Hayes Bridge Retail Park**Hillingdon BC: Consultee Comments on TVIA (2246-21-RP01) dated 21/09/22:**

Green Infrastructure Memo: Stage 1 Consultation (30/09/22)

Hillingdon BC: Consultee Comments on the following landscape drawings:

DRAWING TITLE
LANDSCAPE
CONCEPT PLAN

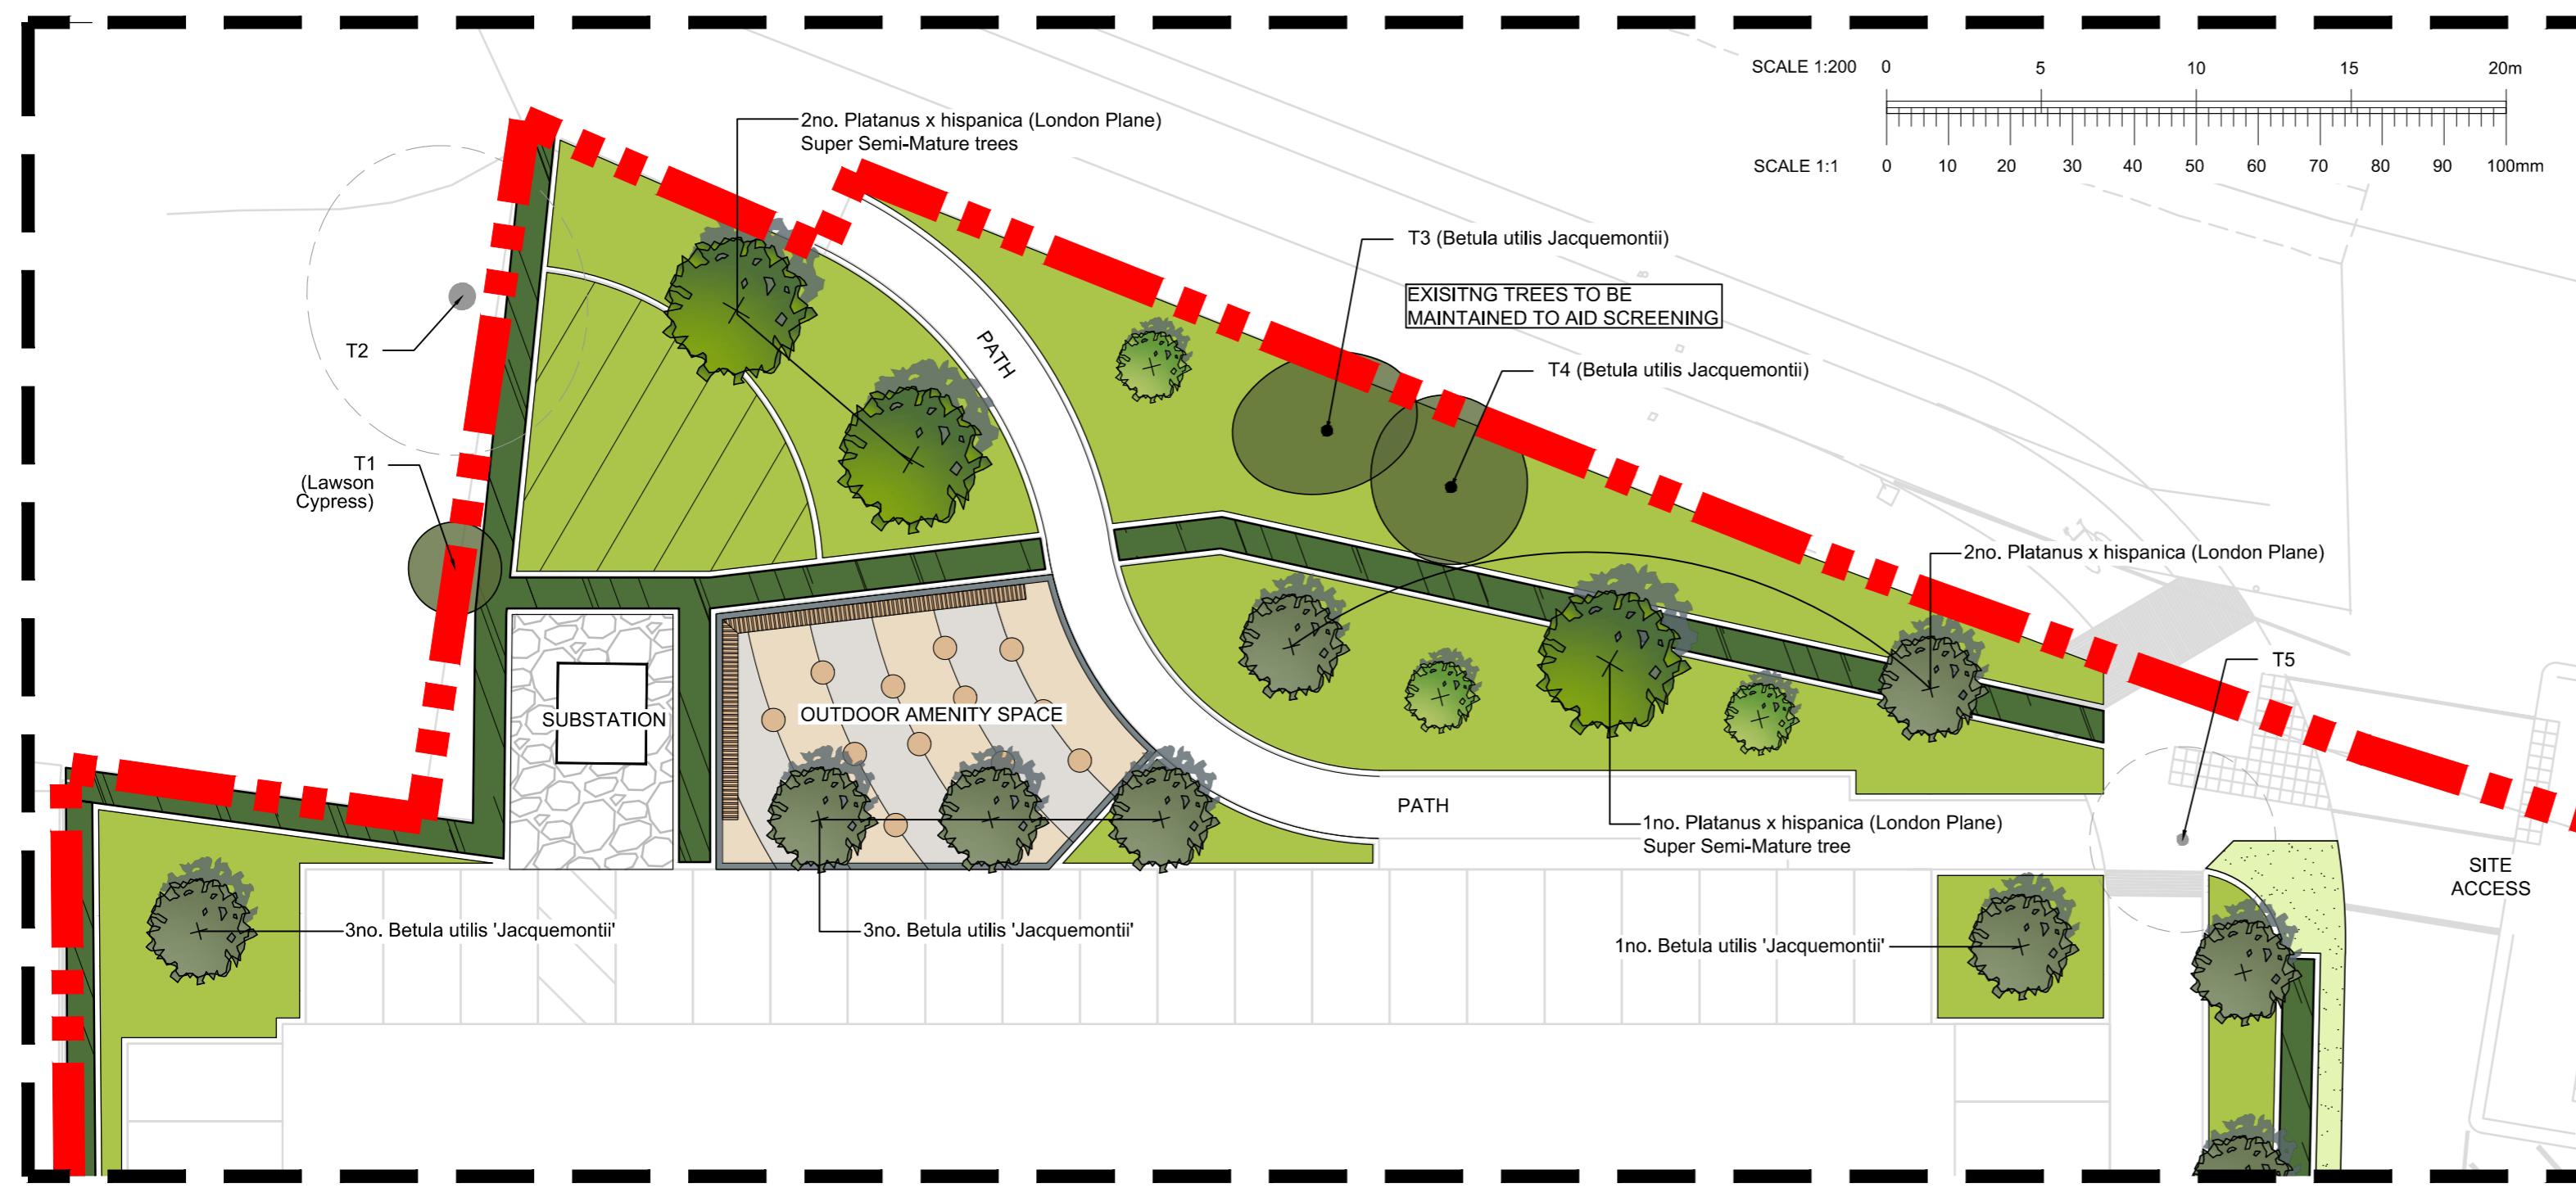
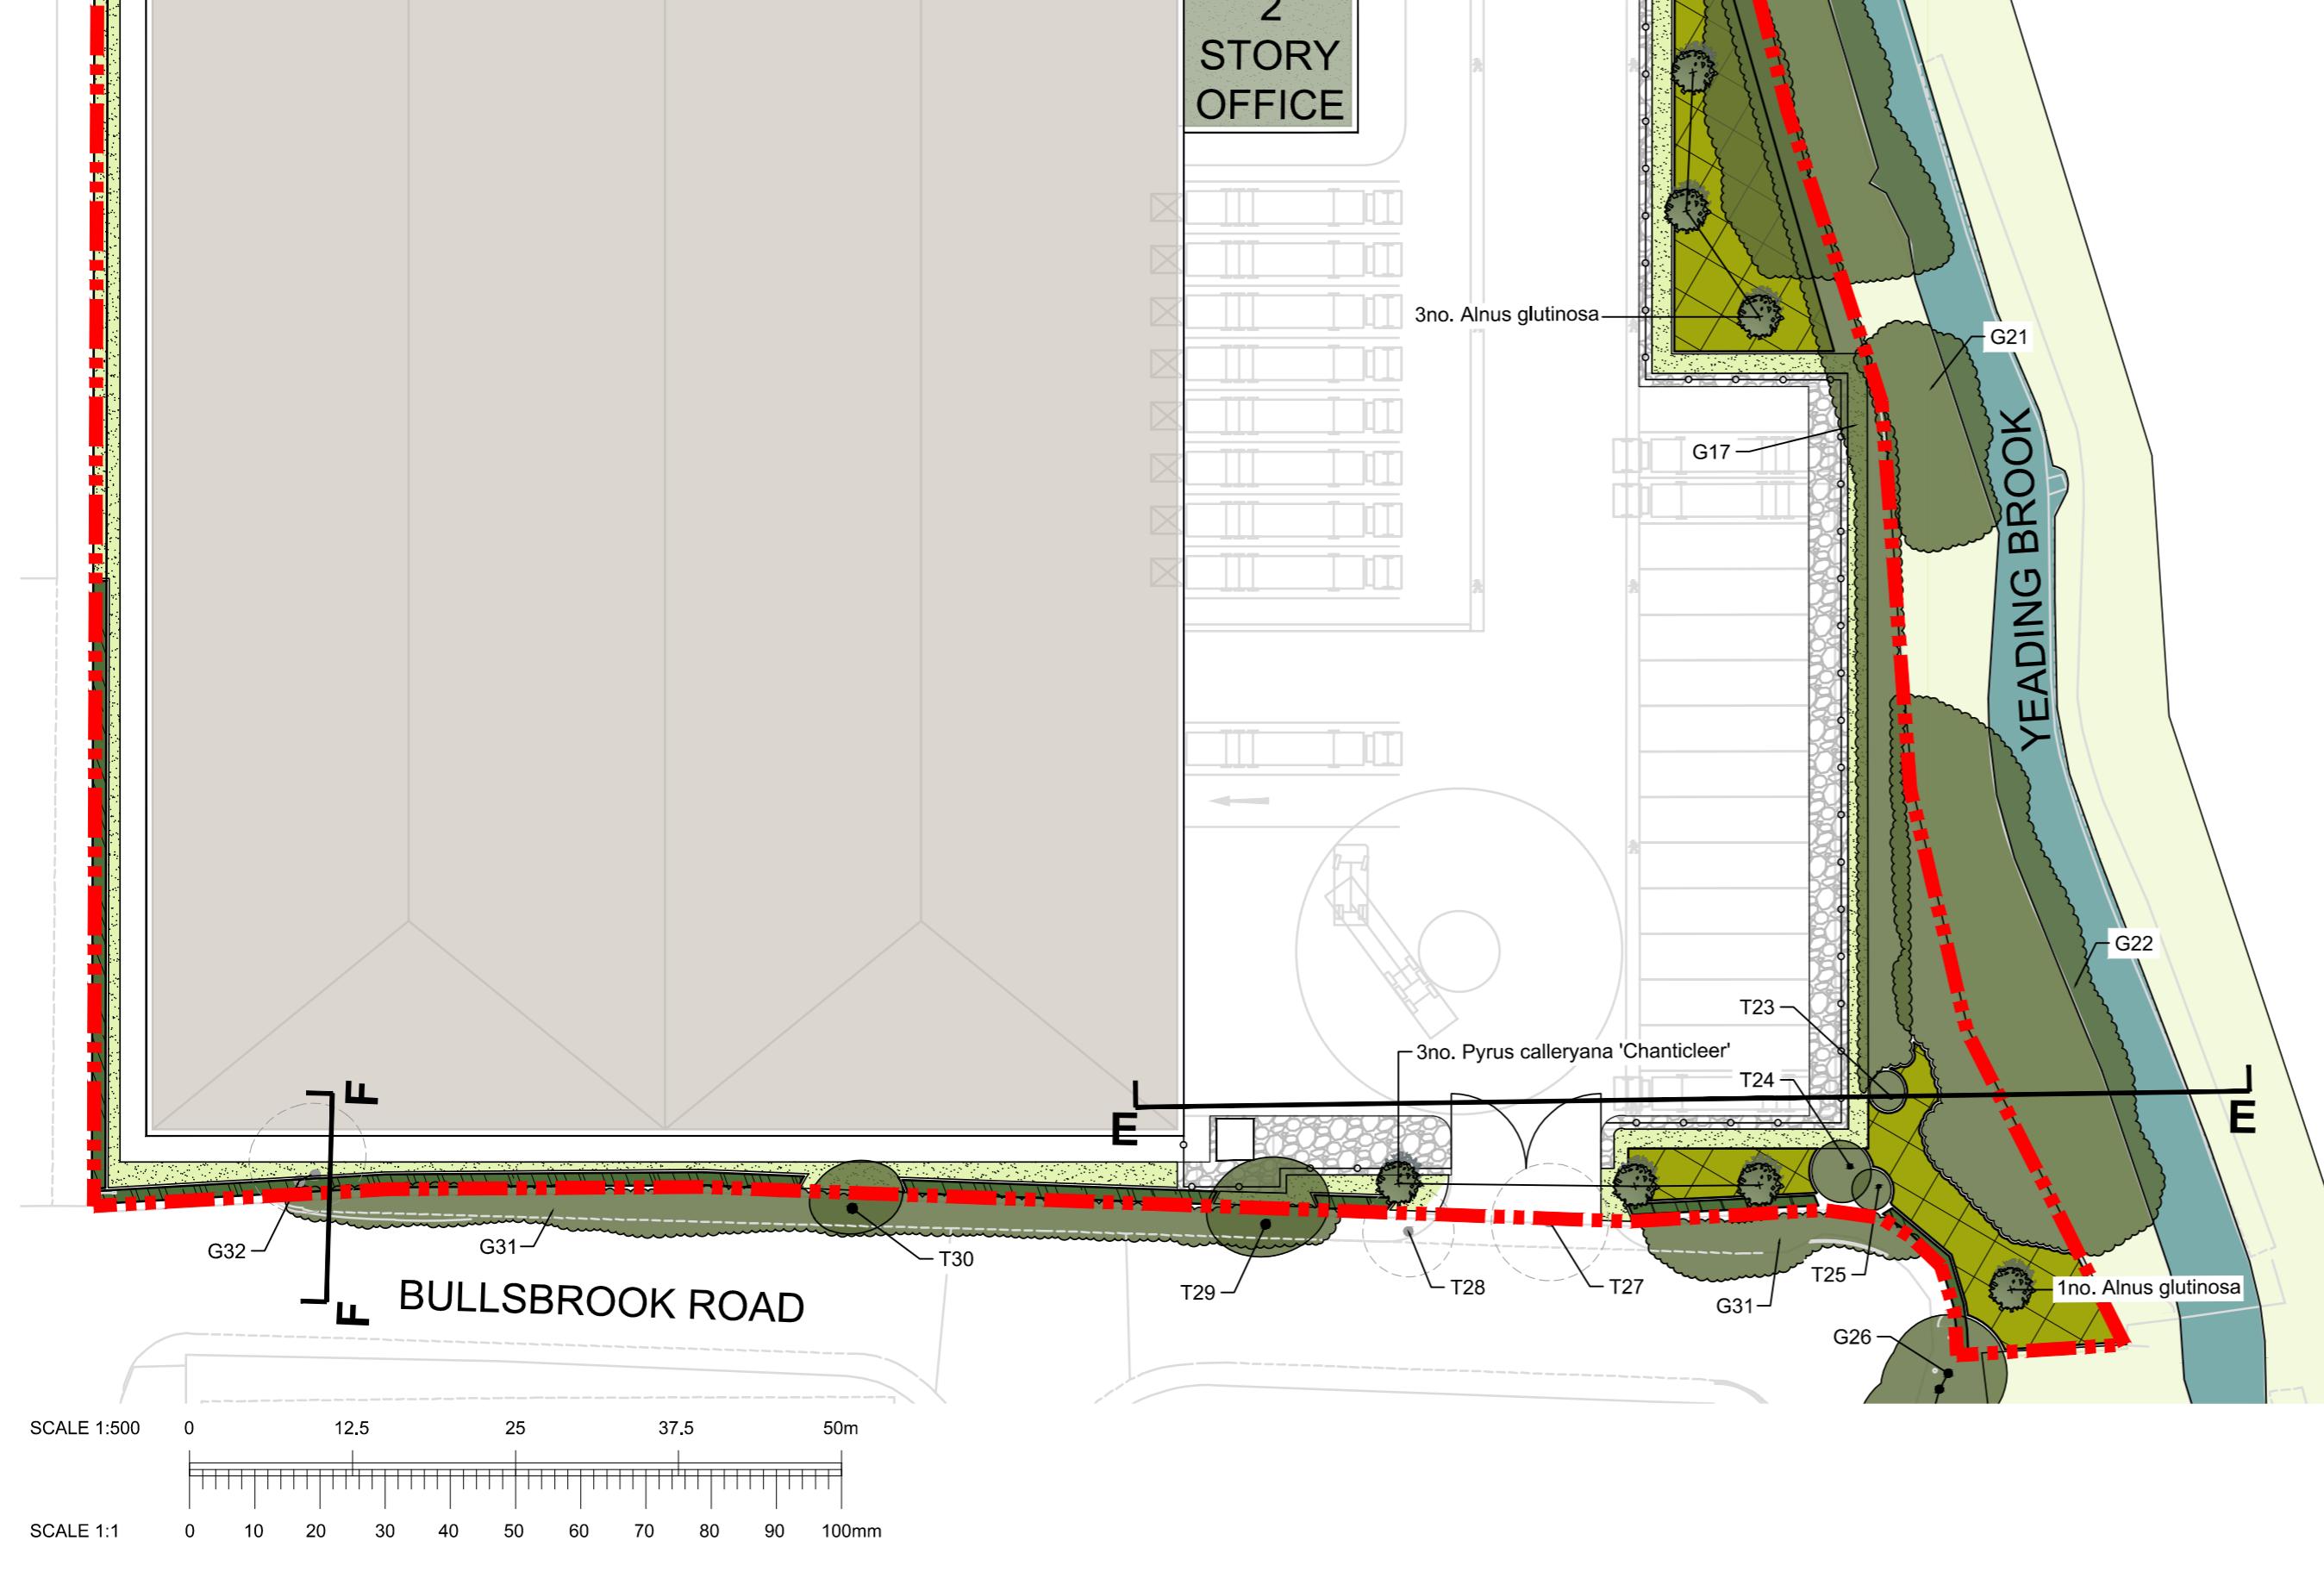
The site's eastern boundary has been enhanced by the provision of a two metre wide strip of soft landscape, taken from the yard area. This strip has allowed the retention of an additional section of woodland group G20, plus the provision of a species rich grassland edge up to the yard fence line.

Improvements to the quality and quantity of urban greening has been made, with the omission of ten parking bays on the northern boundary, allowing the provision of a wider landscape buffer to the Uxbridge Road frontage. This plus the additional vegetation from point 1 above have been added to the UGF score.

Revised Information: Landscape Concept Plan no. 2246-21-03D

Revised Information: Landscape Concept Plan, drawing no. 2246-21-03D
Urban Greening Factor, drawing no. 2246-21-05C
